<b>Application Reference Number:</b>	2026/0070
<b>Proposal Description:</b>	Merger of 2 no. adjoining dwellinghouses into 1 no. combined dwellinghouse. Replacement of front door of no.196 to a window with single storey rear extension.
<b>Location:</b>	196 and 198 Darton Lane, Mapplewell, Barnsley, S75 6AH

Proposed Rear Elevation
Scale 1:100

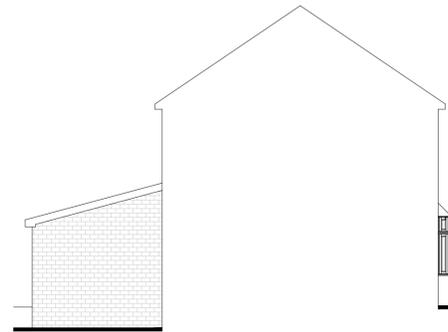
The host property is a mid-terraced property with an existing rear extension not unlike others within the same terraced row. The applicant wishes to infill between two existing extensions which are at the rear of both properties. The height and depth of the extension would match what already exists at the site and as such is established. The length of the extension would be increased to connect the existing extensions. The scheme would not have a detrimental impact on overshadowing, loss of privacy and loss of outlook. Therefore, extension to the rear would comply with Council policies.

The rear extension has been designed to be made from matching materials to the main dwelling house. The scheme would not be seen from the highway and as such would not be seen by the general public. Other properties on this row of terraced houses also have rear extensions of a similar size. It could be argued that the scheme would be an improvement as the applicant is proposing a pitched roof rather than the flat roof which is currently on both existing extensions.

The changes to the front elevation would be minimal with the removal of the front door and the adding of a window instead. This would have little to no impact on residential amenity.

The development would also cause no to little impact on visual amenity as the scheme would be changing the use and the front elevation changes would be the removal of the front door and replaced with a window. These changes are minimal and would not impact on the character of the area.

PROPOSED GROUND FLOOR PLAN
Scale 1:50

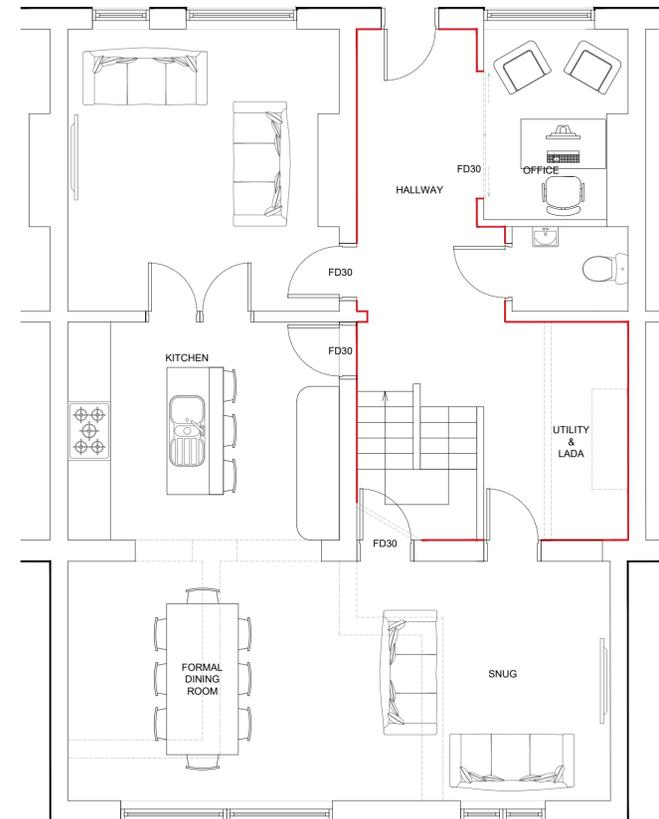
The extension to the rear would be connecting two existing extensions together, to form a large extension. The extension height and depth would match the existing extensions which are already at the site. The applicant wishes to infill the gap in between the extensions. As such the proposal would approximately measure:

- 8.2m (W) x 3.7m (D) x 4.1m (H)
